WEST SUSSEX COUNTY COUNCIL CONSULTATION

TO:	Arun District Council FAO: Anita Gardner
FROM:	WSCC Highway Authority - Matthew Bartle
DATE:	9 March 2020
LOCATION:	Southdown Nursery Old Mead Road Littlehampton BN17 7PU
SUBJECT:	LU/48/20/PL Demolition of 1 No. bungalow & outbuildings & erection of 22 No. dwellings with associated parking & open space. This application is a Departure from the Development Plan.
RECOMMENDATION:	Advice

DRAWING TITLE
Proposed Site Layout Plan

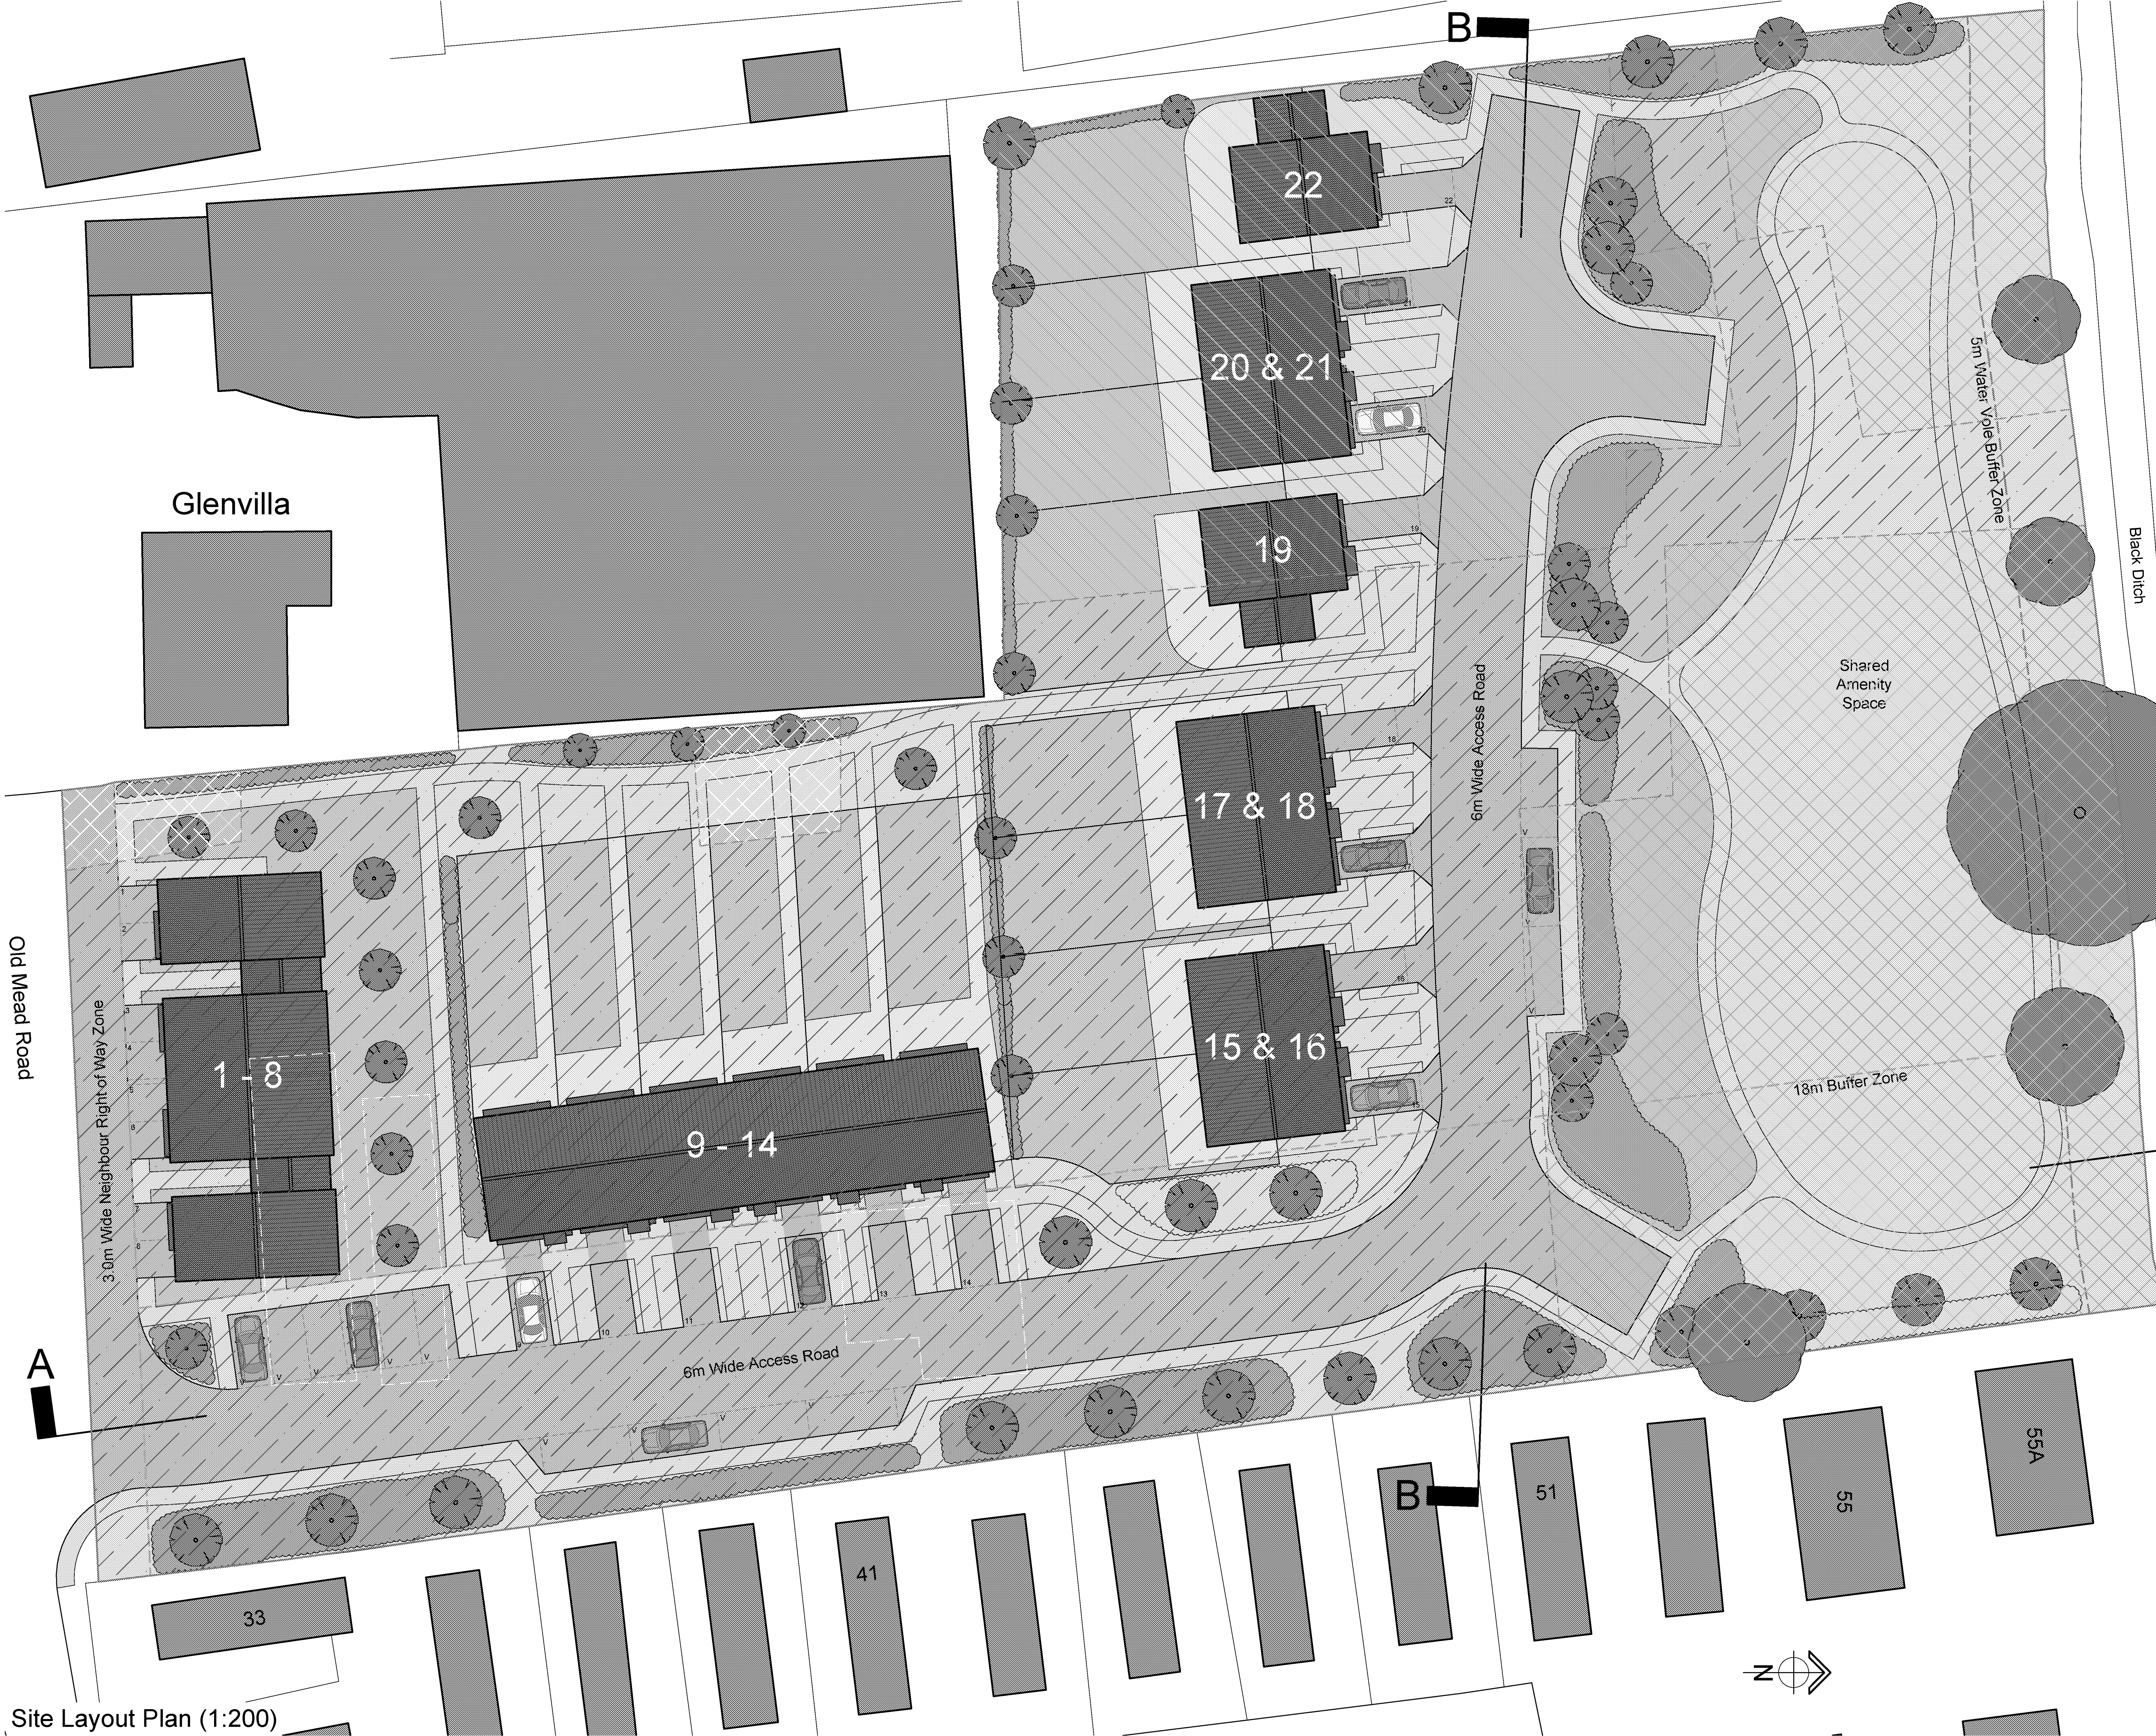
Traffic levels on the west end of Old Mead Road are likely to remain low. However, from the site plan supplied with the application, visibility to the east appears inadequate. In addition, the purpose of the "neighbour right of way zone" is unclear. No vehicle tracking drawings to demonstrate adequate access for emergency and refuse vehicles have been provided. There appears to be little separate provision for pedestrians and the road is currently largely unlit.

It is not clear whether the latest version of the County Council's parking demand calculator has been used to estimate parking demand. We therefore suggest that a condition regarding parking configuration be attached to any planning consent.

To ensure road user safety and consistency with the other main development on the road, we suggest that the applicants review the guidance published in Manual for Streets 1 & 2, and consider whether to incorporate elements of that guidance in their site design. Particular attention could be paid to the road safety aspects of the design.

The highway authority would be happy to consider a revised design based on accepted principles for street design.
